**Southern
Water**

Proposal: Outline planning application (with all matters reserved except for access) for the development of up to 1,500 dwellings (Use Class C3), 60-bed care home (Use Class C2), up to 9,000 sqm of employment floorspace (Use Classes B1), local centre of up to 2,350 sqm including up to 900 sqm retail / commercial (Use Classes A1-A5) and 1,450 sqm community / leisure floorspace (Use Classes D1-D2), land for a two-form entry primary school (Use Class D1), public open space, allotments, new sports pitches and associated facilities, drainage, parking and associated access, infrastructure, landscape, ancillary and site preparation works, including demolition of existing buildings and part removal of existing runway hardstanding. This application affects a Public Right of Way. This application is the subject of an Environmental Statement. This application falls within CIL Zone 1 - Zero Rated.

Site: F/4/20/OUT: - Land at Ford Airfield Ford, West Sussex BN18 0HY.

We write further to our letter dated 24/11/2021 and in response to the issuing of planning condition 35 for application F/4/20/OUT.

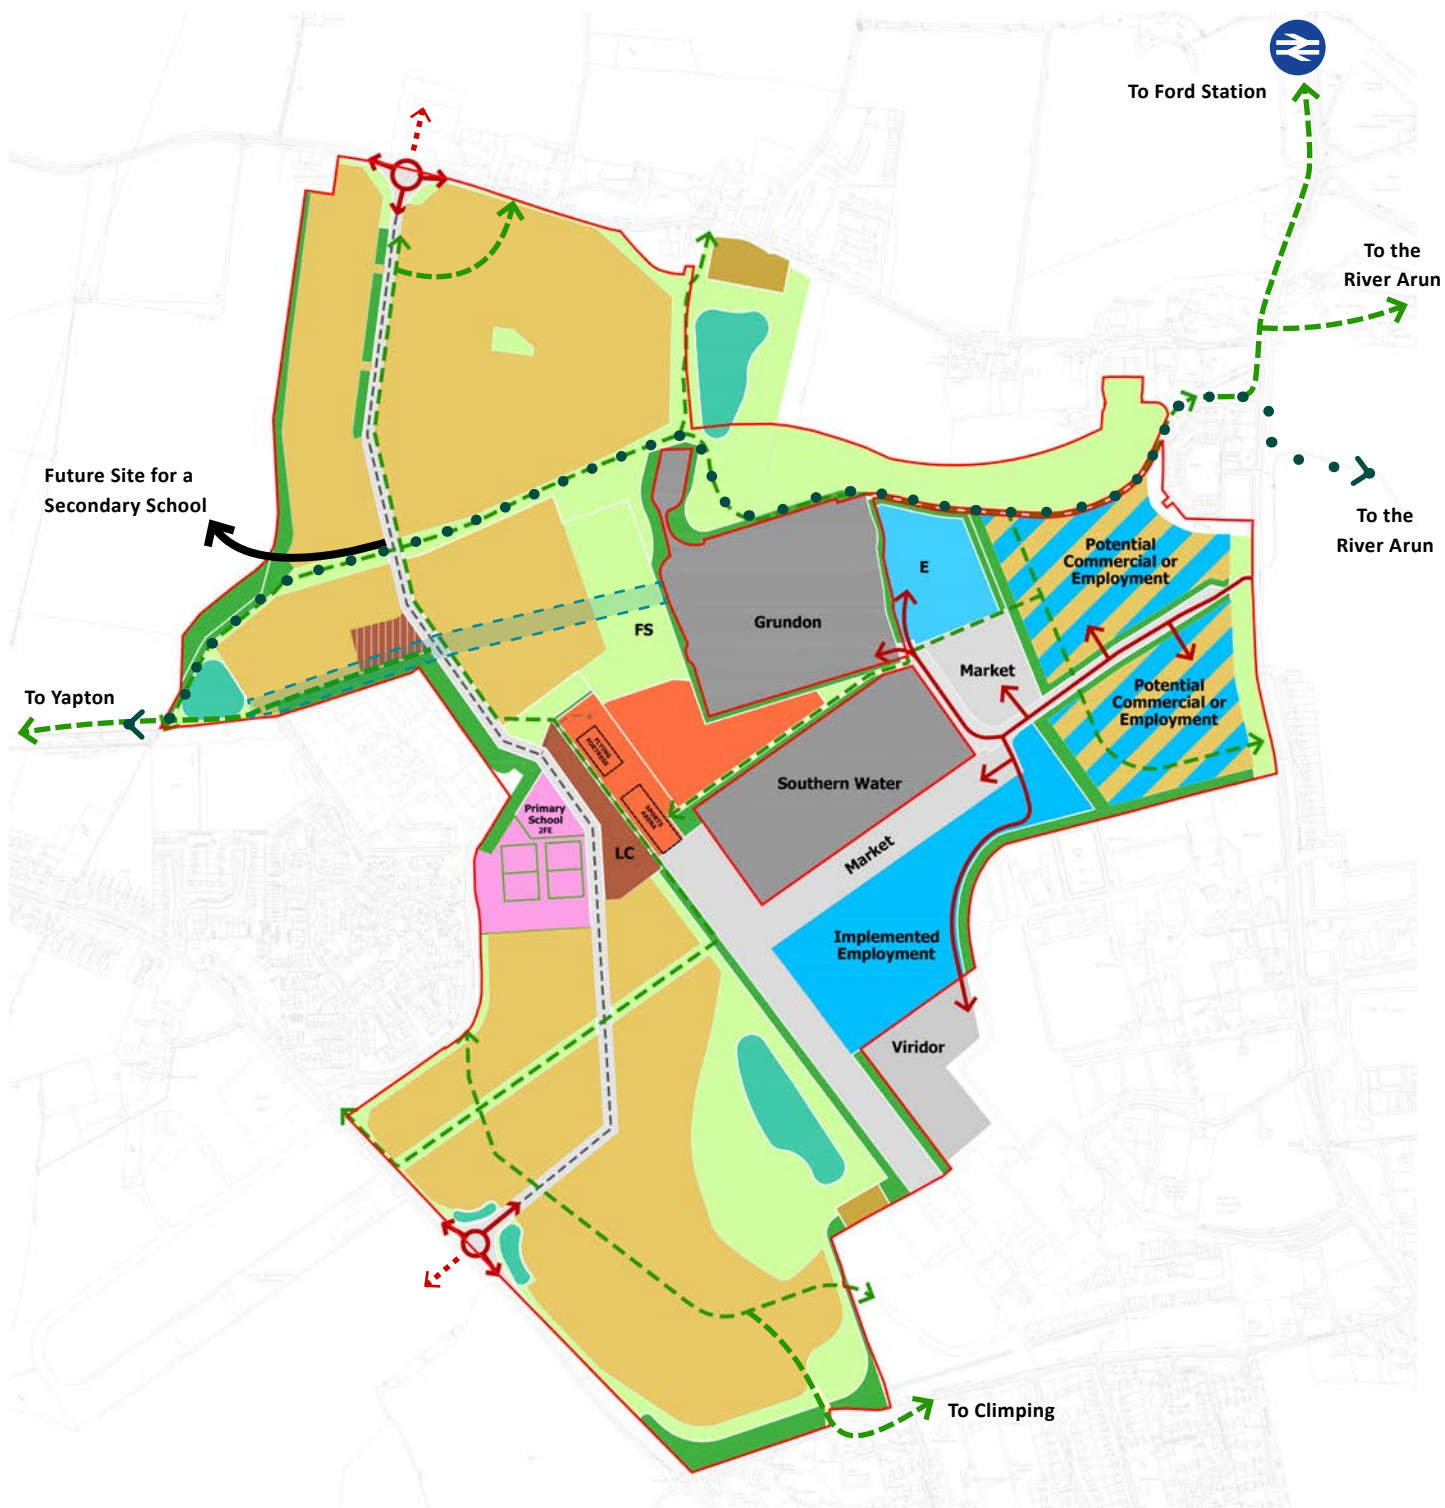
- The Masterplan is developed based upon the location of the 3 ouE/m³ as the 98th percentile of hourly averages contour. As a sludge processing site, we highly recommend the use of the Environment Agency H4 odour guideline of 1.5 ouE/m³ as the 98th percentile of hourly averages contour.
- The 'sniff tests' conducted by both Hoare Lea (representing the developer at that time), and Phlorum (representing the Local Authority), both observed strong and significant odours in positions outside the modelled area of odour constraint. This shows that the model is likely to be understating the potential area of future odour effects.

Southern Water was only given a red line outline boundary plan to provide comment upon in the 2021 consultation. The suitability of subsequent placement of land uses within the proposed area of odour constraint have not been assessed.

- These land uses (school playing fields and employment land) are defined as having a medium sensitivity to odour.
- They are located within the both the predicted odour contour and suggested 300m buffer zone.
- No assessment of the potential for odour effects and suitability of the land use at these locations has been conducted to date to our knowledge.

## Appendix B – Walkover Surveys: Locations

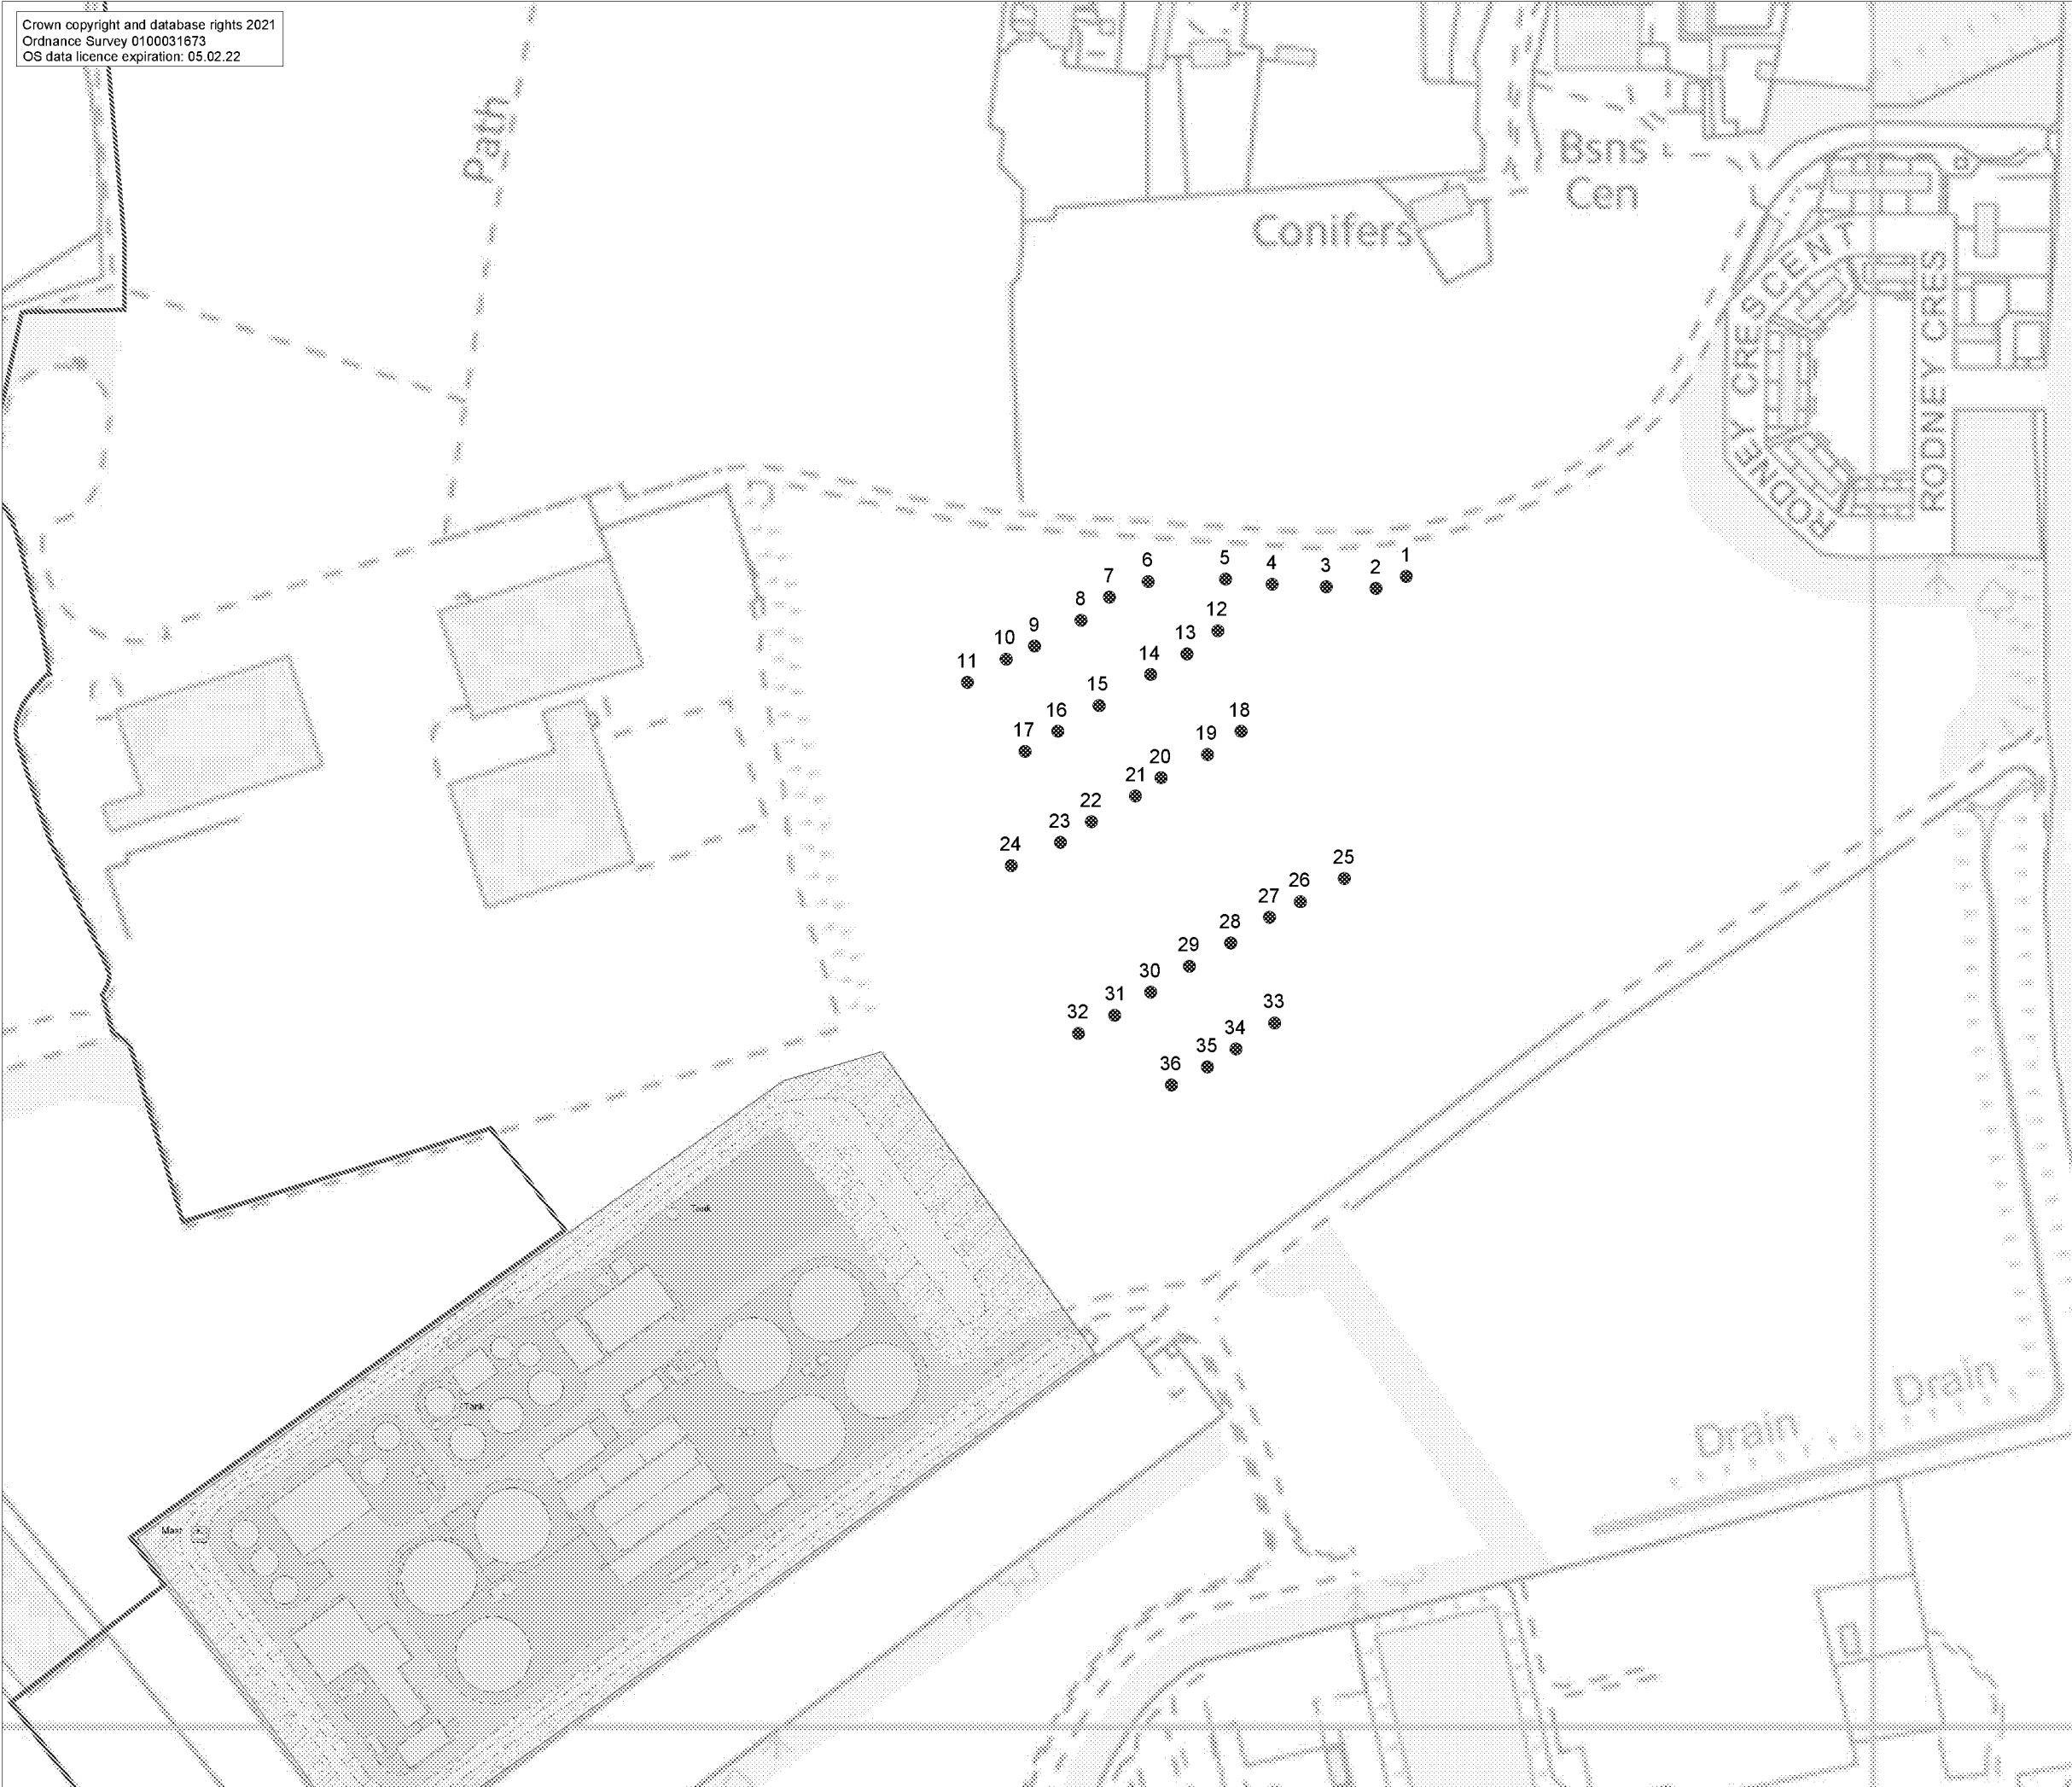
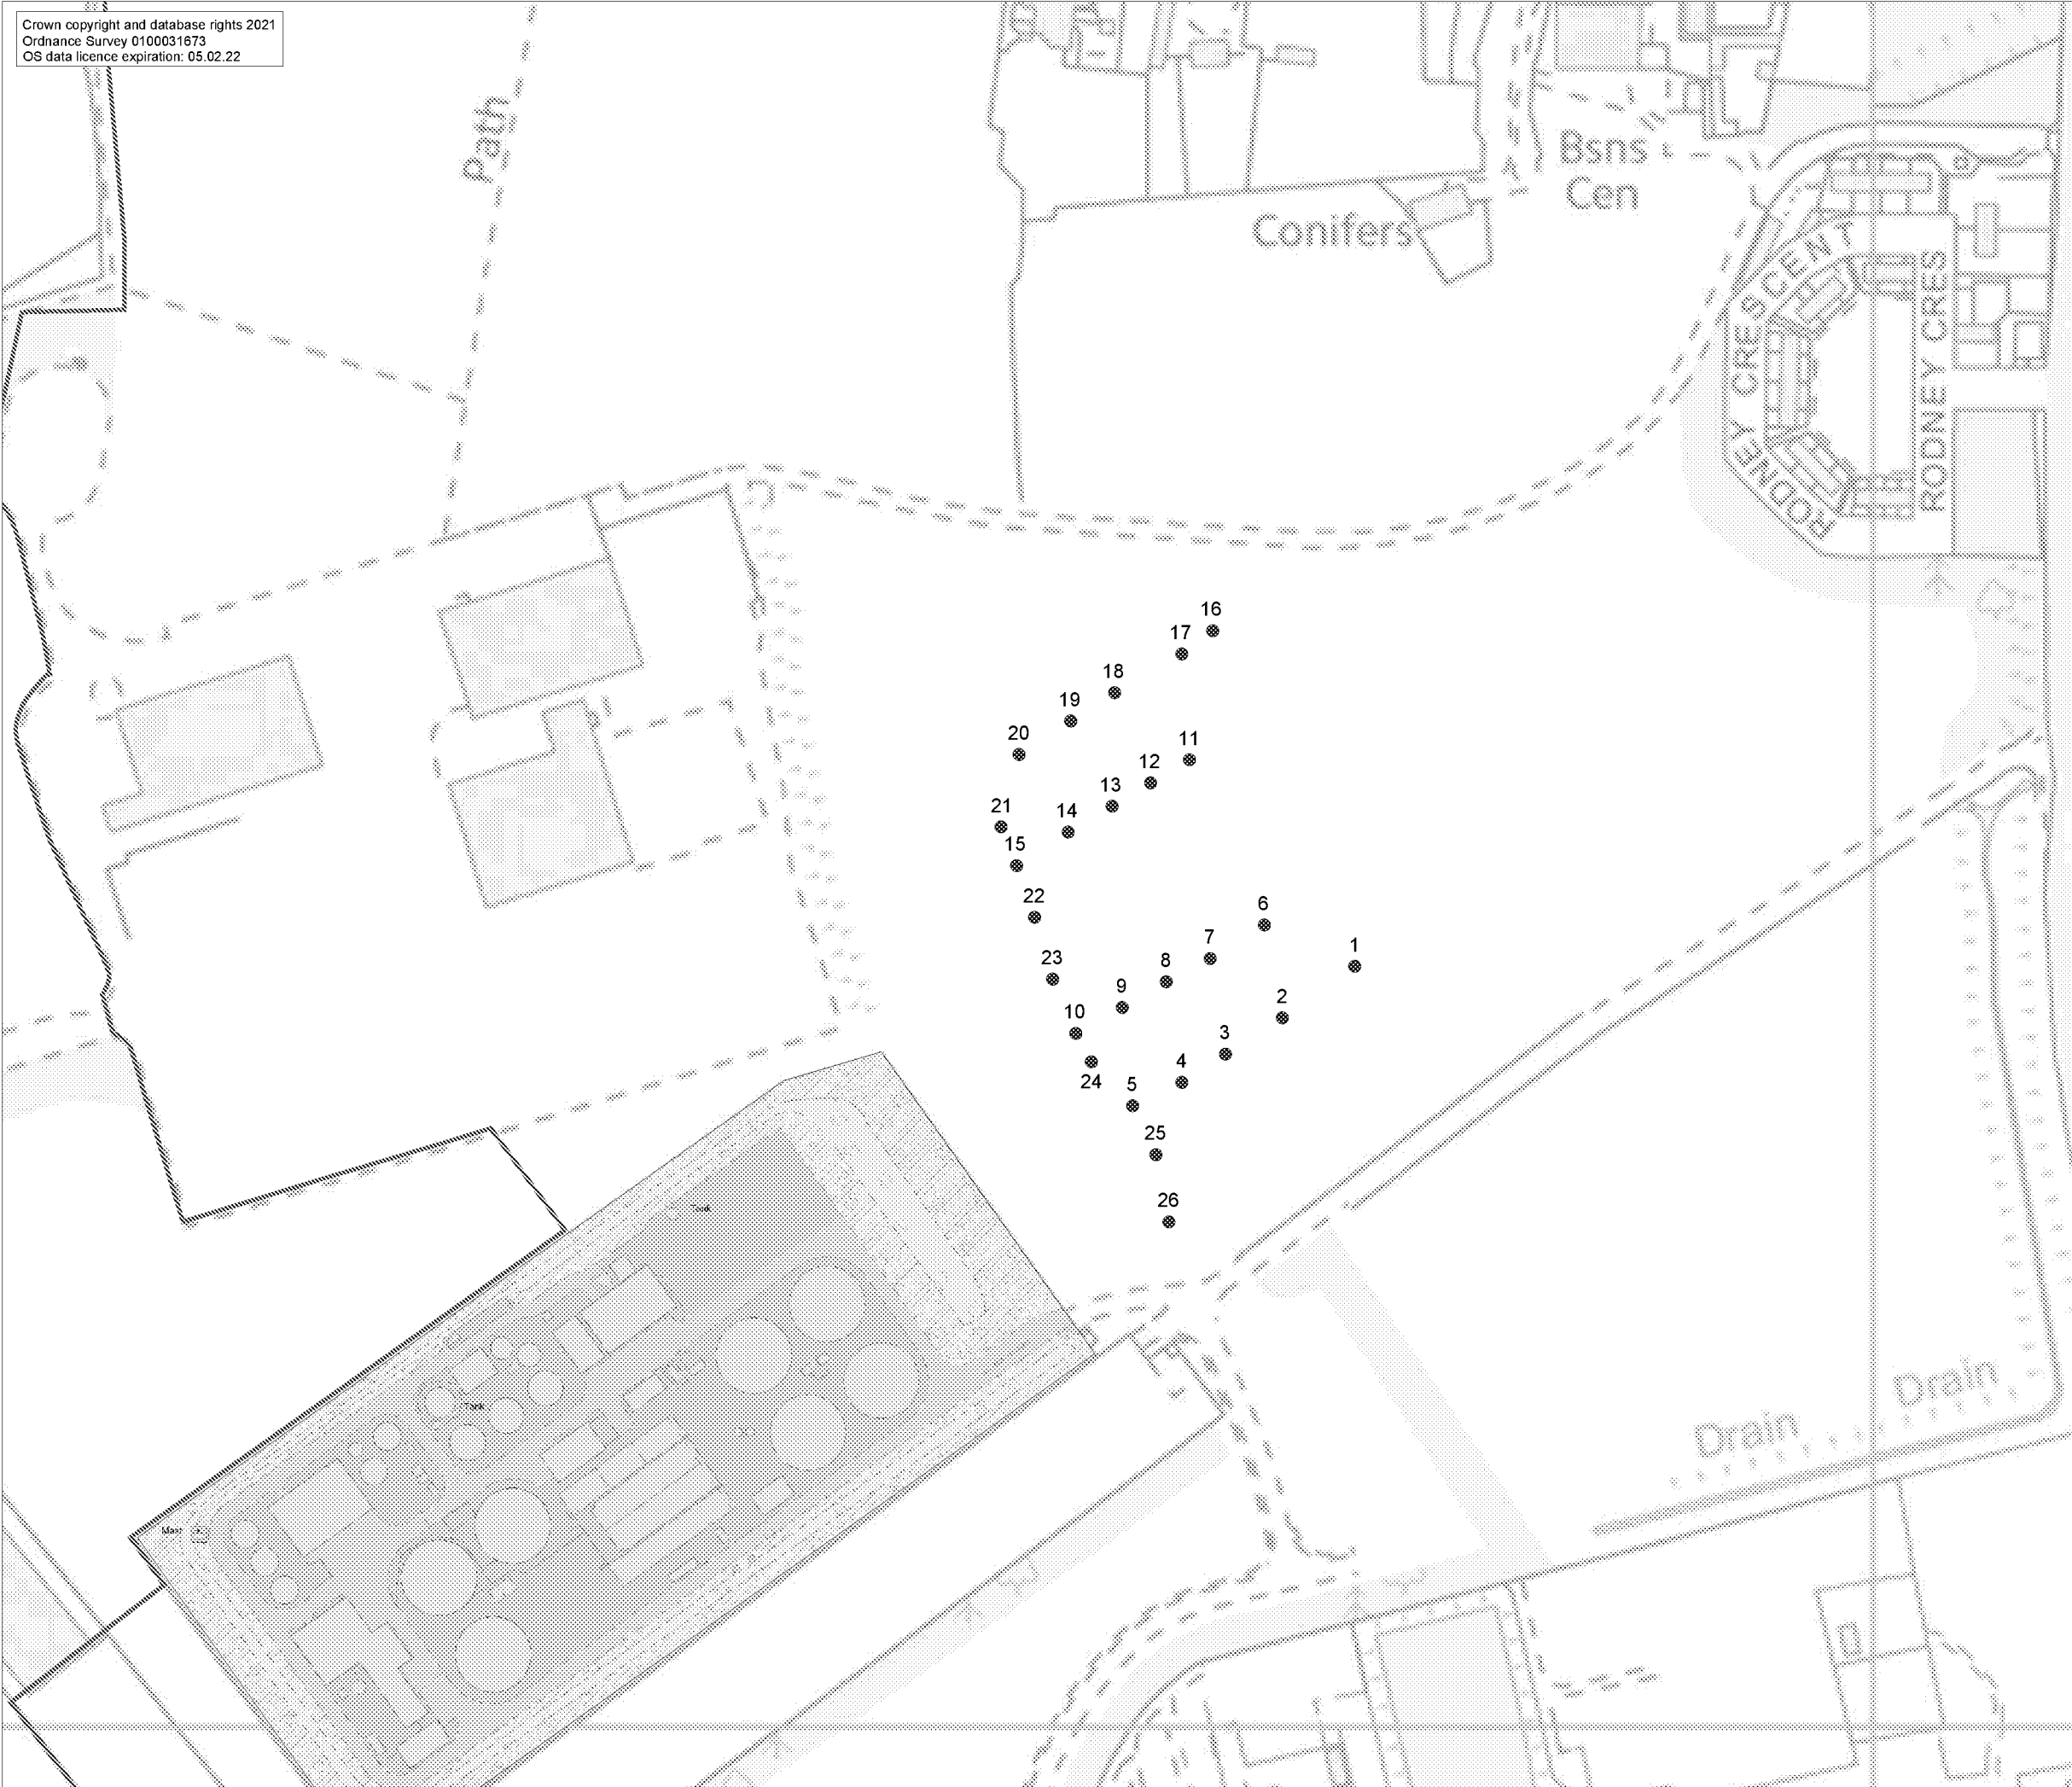
Condition 35 of the application, requesting a 300m buffer from the ASP, seems to be a misinterpretation of the advice provided by the Council's odour advisors.

The 300m buffer should be the area drawn from the ASP, Main OCU and Sludge OCU rather than just the ASP. The OCUs were identified as the 'most odorous part of the WwTW' and emissions from these areas, observed to be 'moderate' and significant, were detected at distances up to 300m in odour surveys.

Please can we receive a response advising as to why the buffer distances were applied only from the ASP and not the other 'main odour' sources identified by the assessment. Emissions from these sources were detected in excess of 300m from the source, noting the following quotes from the November 2021 Phlorum odour assessment review:

- "2.30 During walkover/sniff test 1, strong odours could be detected transiently but regularly up to 120m from the WwTW boundary, and at least 300m from the most odorous part of the WwTW, i.e., the main works odour control unit. The three locations where strong odours could be detected were not the three closest, as is suggested in the report, suggesting that a plume from the OCU might be grounding there".
- "2.4. Such discrepancy between modelled and observed results should point to the adoption of the precautionary principle. If unacceptable odour contours are predicted to occur 300m from sludge processes, then this ought to be considered the radius in all wind directions where such odours could affect the application site. This would be a more robust way to inform the appropriate layout of the masterplan."
